Application reference number	2024/0676
-------------------------------------	-----------

Proposal Description:	Construction of building for social care providing supported employment
Location:	Land behind 5 and 6 Beacon Close, Silkstone Common, Barnsley, S75 4PY

Recommendation: **REFUSE Planning Permission**

SITE PLAN SHOWING
SEWERS FROM YWA
RECORDS

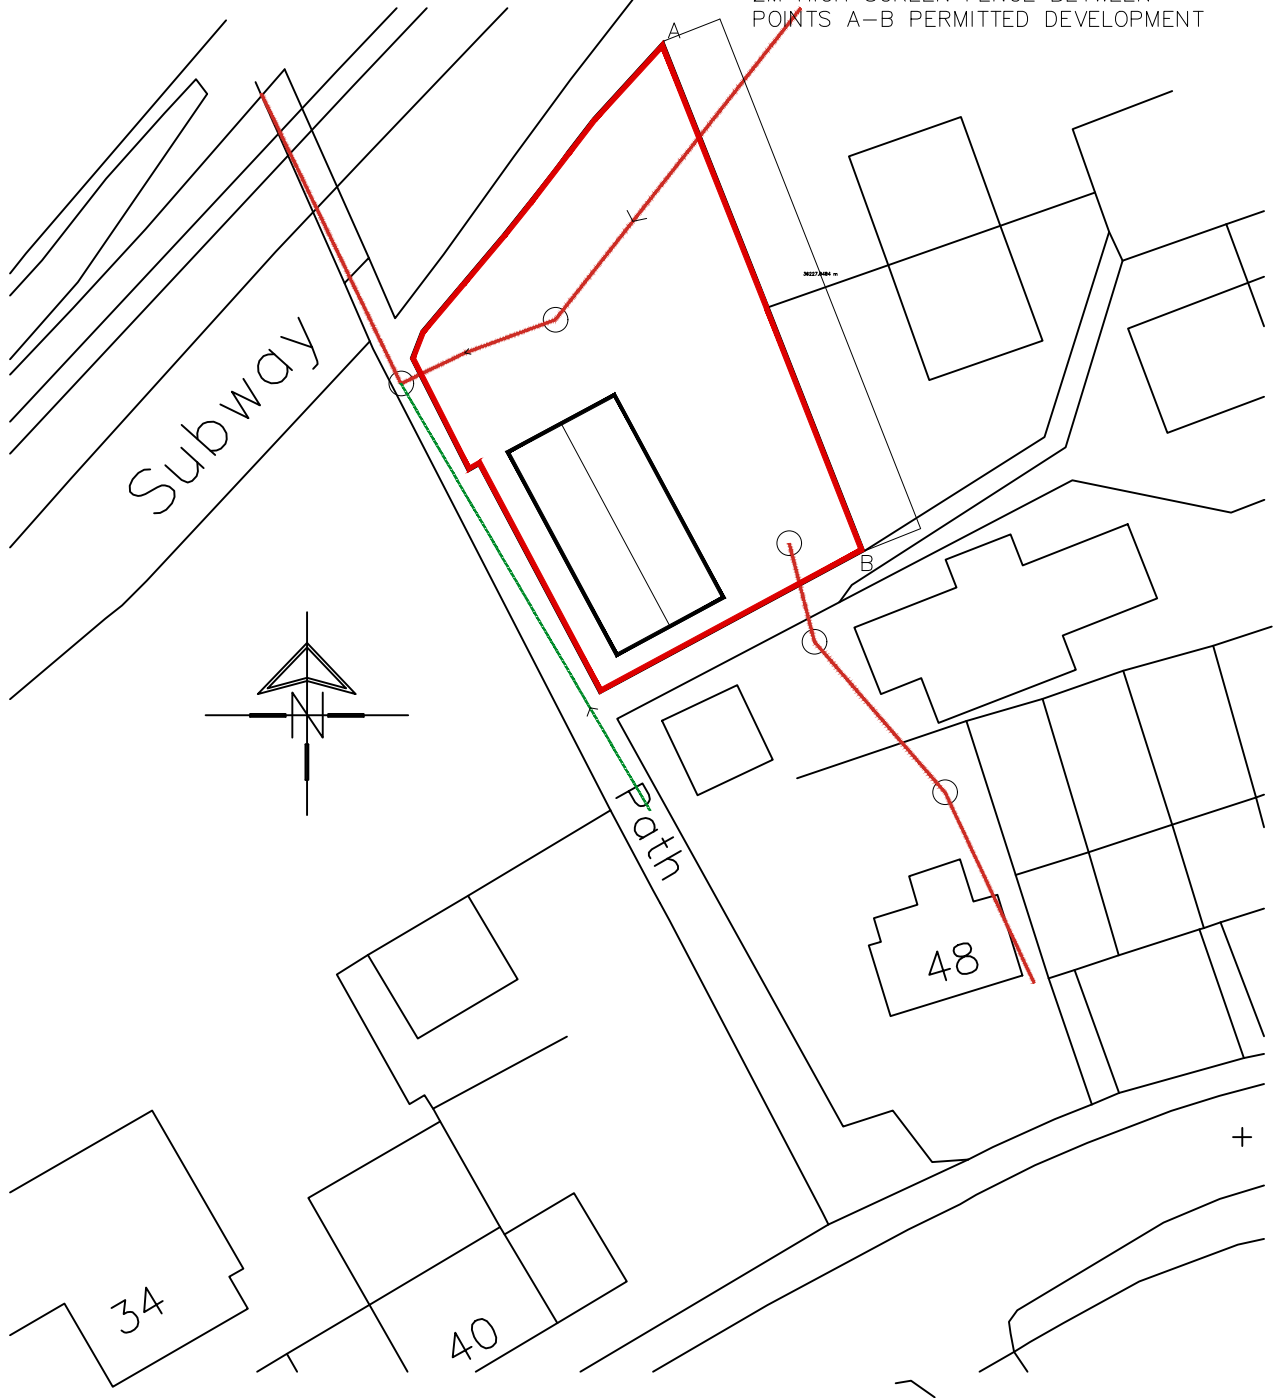
The submitted application site does not include within the red outline the means of vehicular access to the site. In a number of submissions, it is indicated that the application site has the benefit of vehicular rights of access over a public right of way. However, insufficient evidence has been submitted to demonstrate that there is a lawful vehicular right of access to the application site. This raises concerns both in relation to the deliverability of the proposed development and the likelihood of highway safety conflicts during construction and use of the building. The applicant has submitted two versions of a construction traffic management plan but neither of these include sufficient detail to indicate how the building could be safely constructed. The applicant contends that the public footpath is 3.8m in width but this is not

true for a significant length of path between the site and Ben Bank Road. There is no provision for emergency, delivery or service vehicles and the suggested construction vehicles would not get to the site while leaving a 0.5metre clearance on either side of the path. No swept path analysis has been submitted to show how vehicles would safely enter and exit the site in a forward gear or without causing a safety issue on a public footpath.

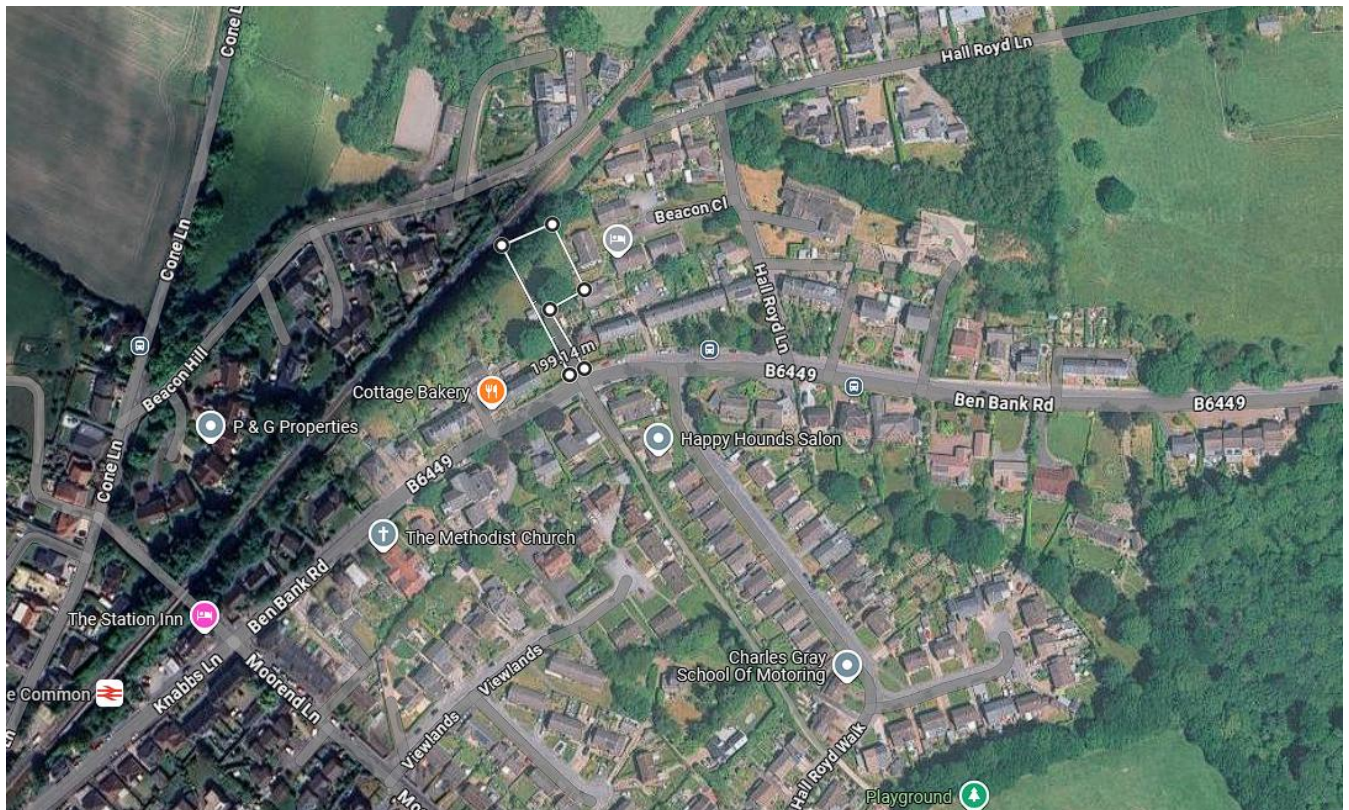
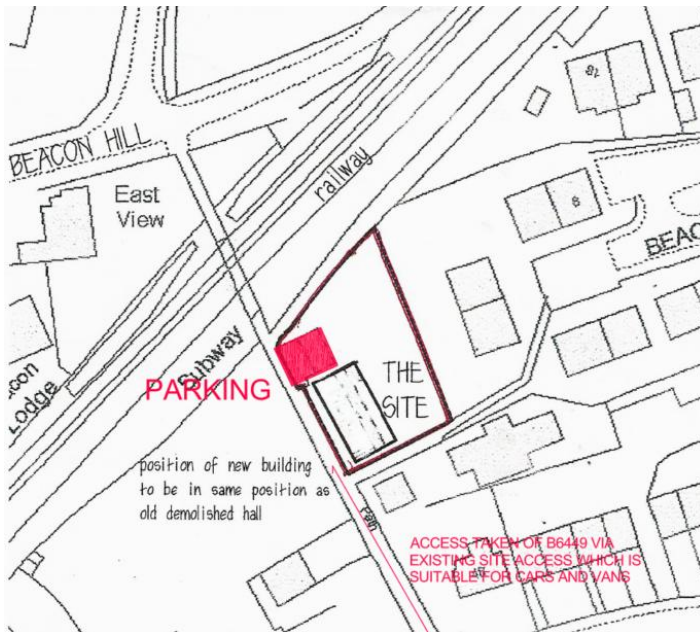
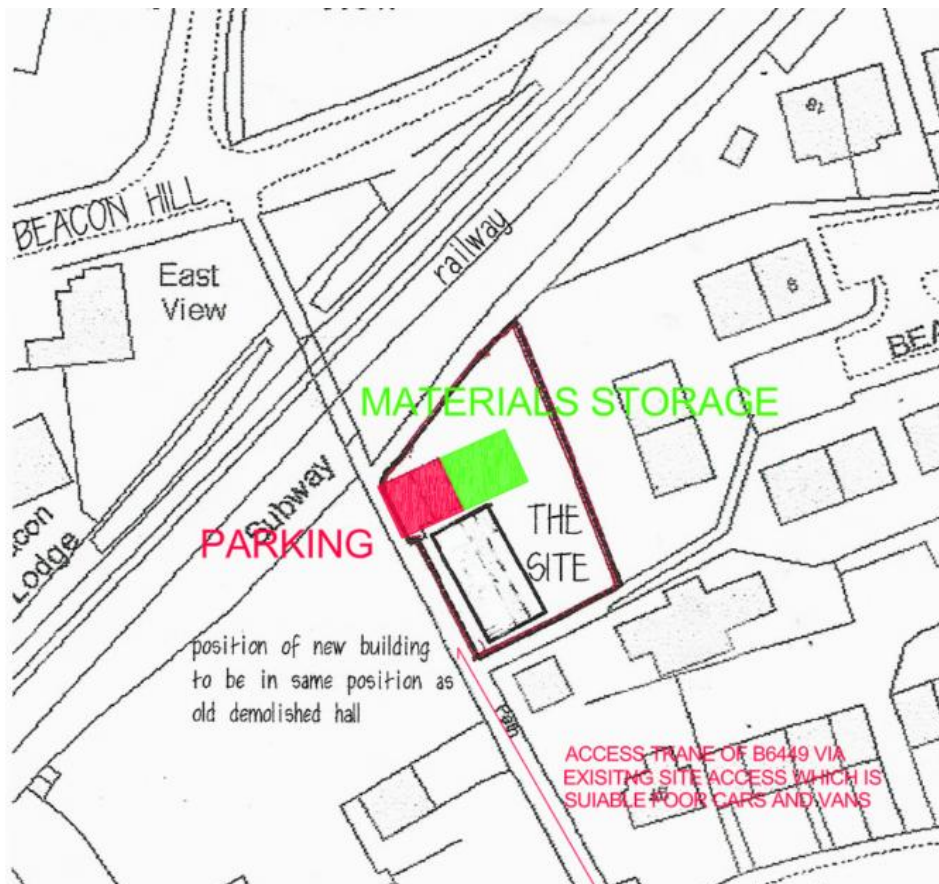
- Further comments objected advising that the amended construction traffic management plan lacks sufficient details and repeating the previous comments.

REAR ELEVATION (facing beacon close)

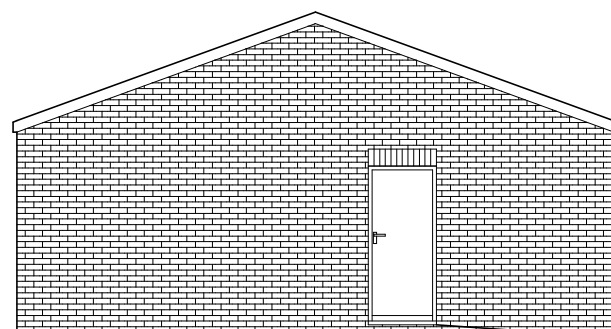
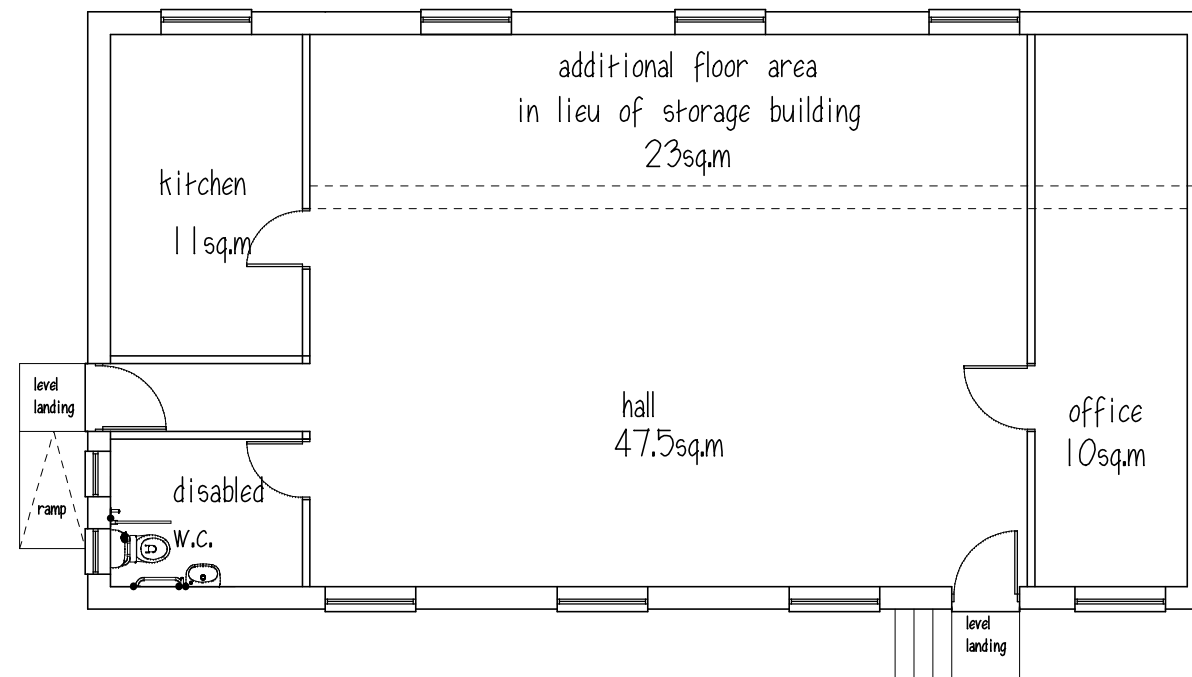
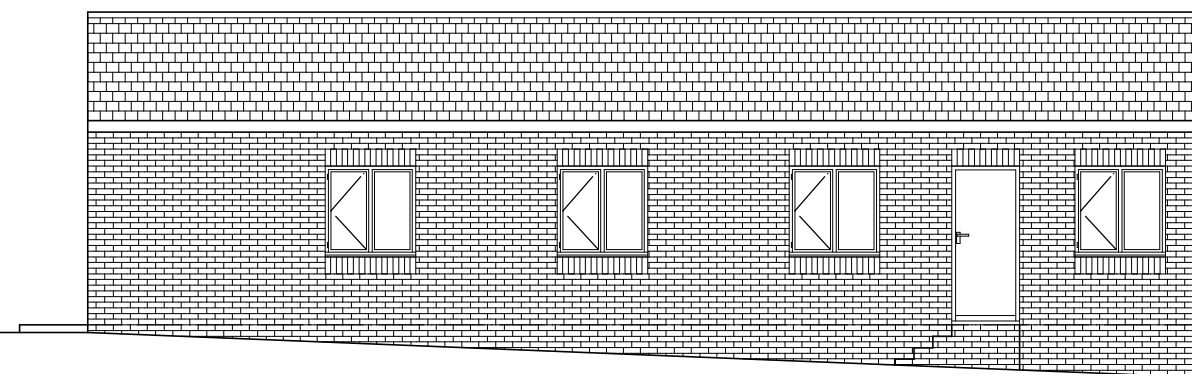
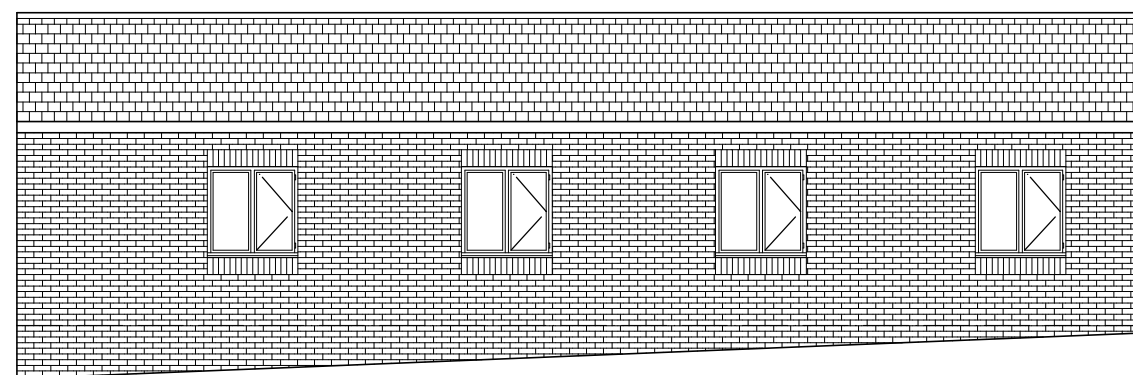
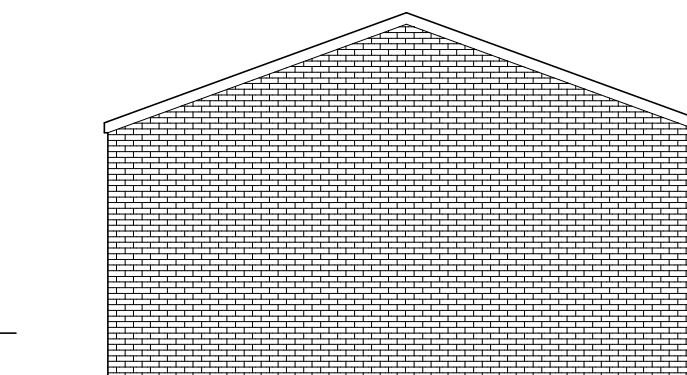
However, there are concerns about the proposed use of the building that indicate that the impact on residential amenity arising from use would be likely to result in significant adverse effects on the living conditions and residential amenity of existing residents. The proposal indicates a very limited use of the building, amounting to no more than 8 people at any one time, and planned to be used for between only 13 and 19 hours in total between 9am and 3pm on Mondays to Fridays. However, the proposal does not clarify why a building of 120 square metres is required for use by only 8 people. It is not clear that the use of conditions could reasonably be expected to control the use of a building which appears to be larger than necessary for the number of people indicated.

In addition, the relationship with the neighbouring dwellings has been raised with the applicant. Original plans for the outside areas of the site to be used as an allotment with additional buildings such as greenhouses planned to be erected have been withdrawn but more recently a reference to a greenhouse has been re-introduced at a late stage. Prior to this, the proposal indicated that use of the outside areas would be limited to maintenance of wildflower gardens, hedgerows and trees which is unlikely to cause any unreasonable disturbance to neighbours. The impact of overlooking from the building has been raised and the applicant has confirmed that the windows facing the nearest dwellings will be removed from proposal, but no amended plans have been submitted. The submission of an amended site plan has clarified that the proposed building would be sited 19 metres from the nearby bungalows to the east, which is considered acceptable. There would be approximately a 9

metre distance between the proposed building and the bungalow to the south-east, but as the buildings are sited at right angles to each other and the bungalow has significant hedgerow screening on its boundary, it is not considered that there would be any unreasonable overlooking or overshadowing of the existing dwelling.
